August 8, 2006

**Re: Status of Improvement Permit Application #06-5-15408
Laurel Valley Lt 103**

On August 7, 2006, an Environmental Health Specialist from the Harnett County Health Department attempted to evaluate your property for the purpose of issuing an Improvement Permit. This individual was unable to evaluate your property for one or more of the following reasons.

SURVEY FOR:
PROPOSED PLOT PLAN - LOT - 103
WOODSHIRE S/D, PHASE FOUR

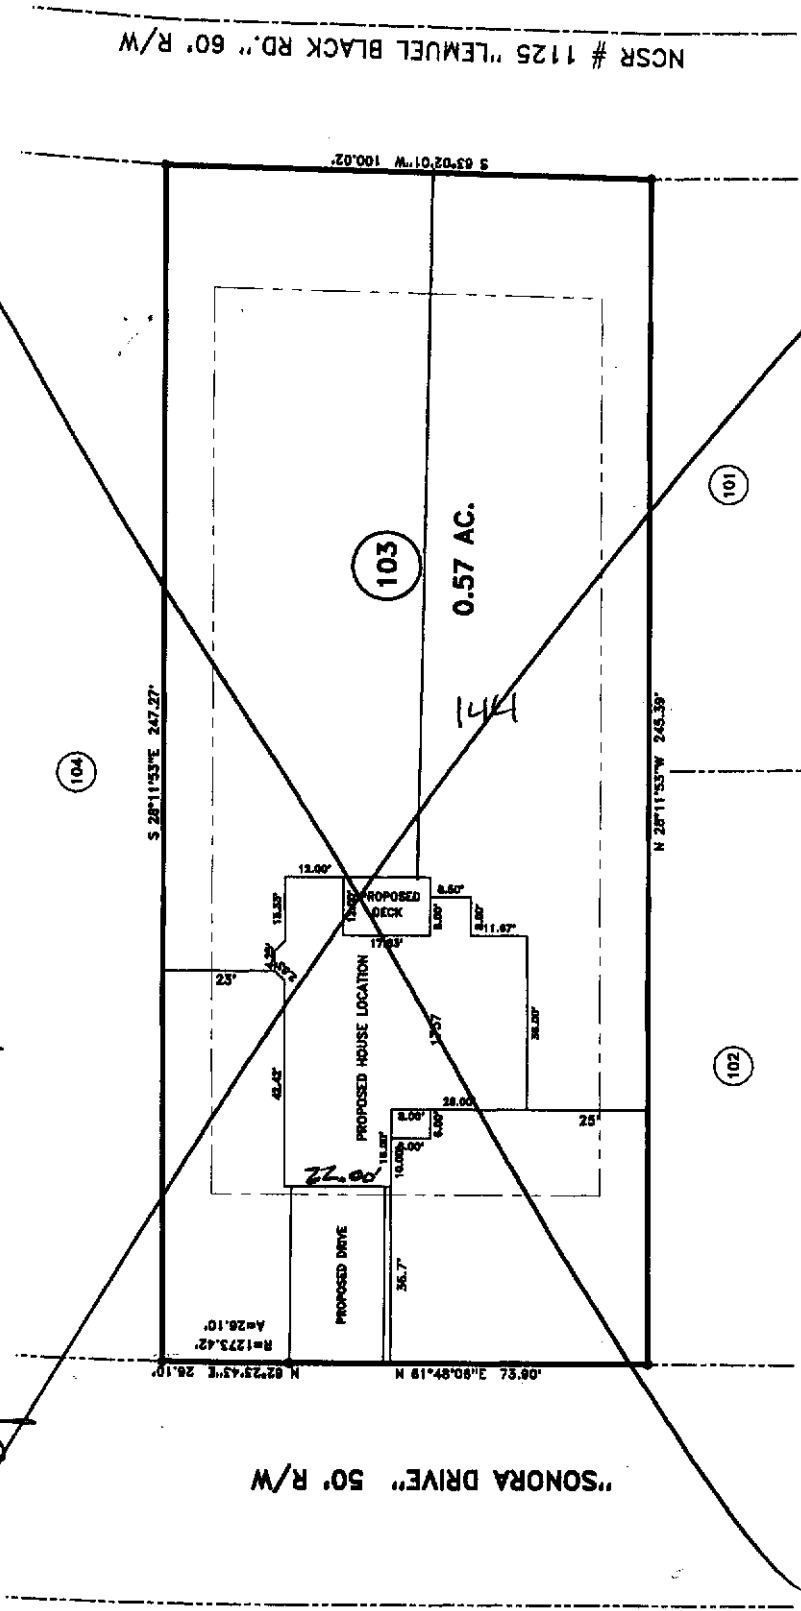
- 1. Property lines/corners not marked or labeled
- 2. House corners not marked or labeled
- 3. Directions not clear to property
- 4. Property needs brush or vegetation removed
- 5. Backhoe pits required
- 6. Other – Home must be a maximum of three bedrooms. Please submit changes from a four to a three bedroom home to Central Permitting.
